Addendum No. 1

RE: Contract ID: C202408

US-501 Business From South of SR-1669 (Club Boulevard) To
SR-1443 (Horton Road) and 8 Sections of Secondary Roads

The following revision has been made to the Sketch Maps:

PROJECT NO.	SHEET NO.	TOTAL SHEETS
5CR.10321.12, 5CR.20321.12	8

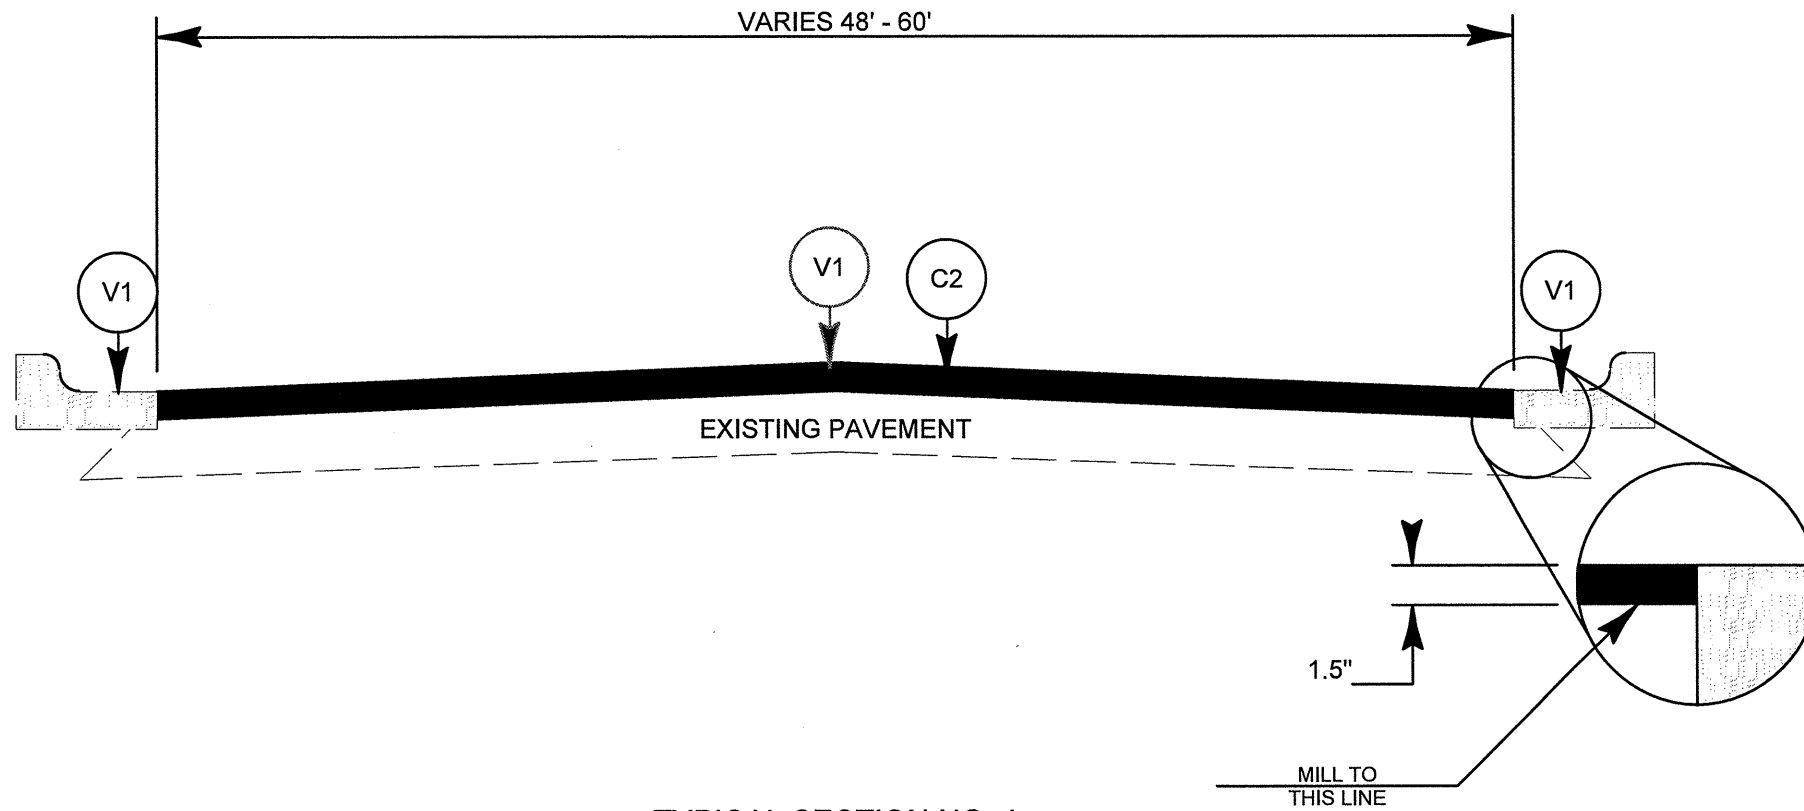
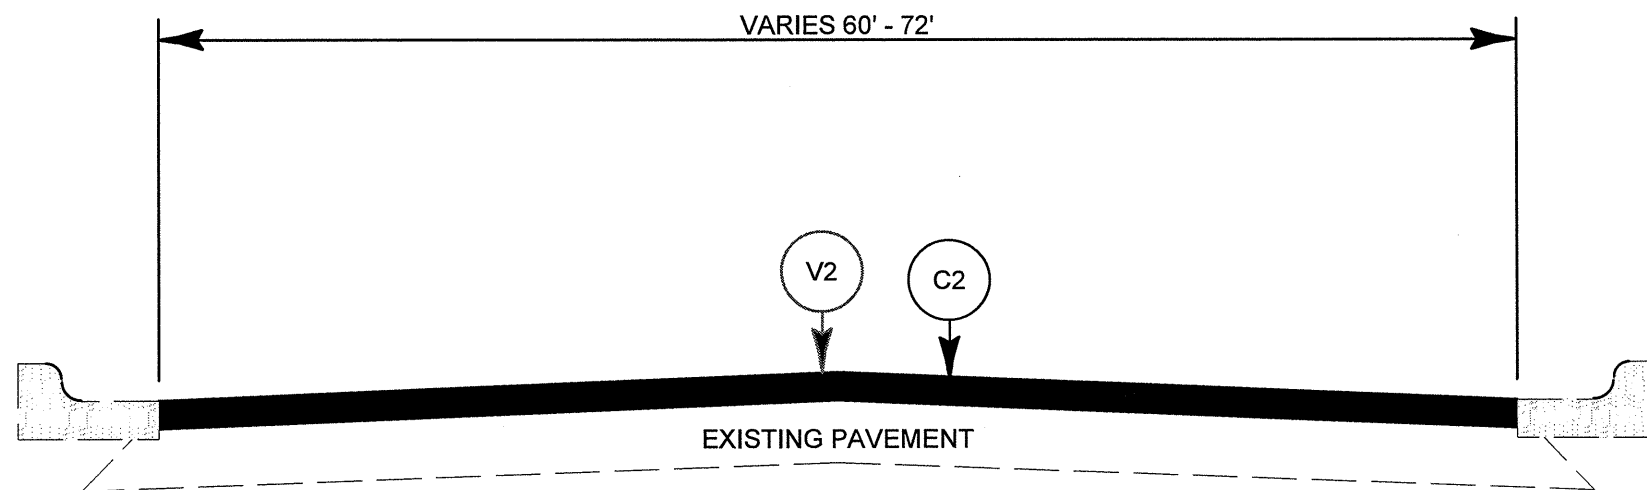
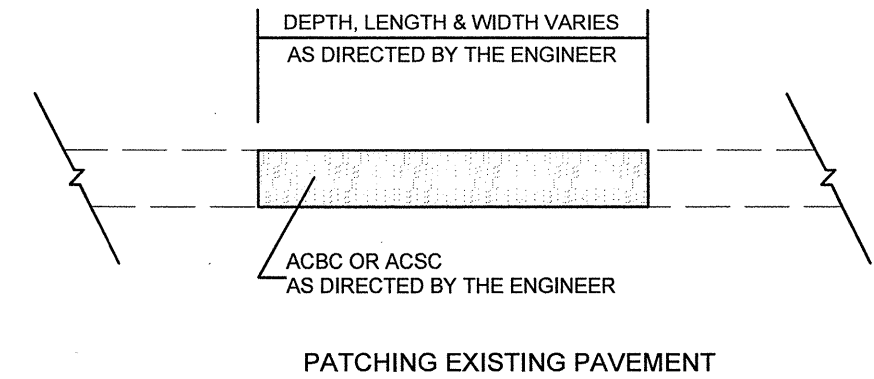
On Sheet No. 8, on the "Pavement Schedule" chart, "V1" has been modified to indicate that it includes milling the existing asphalt in the gutter. Please void Sheet No. 8 in your sketch maps and staple the revised Sheet No. 8 thereto.
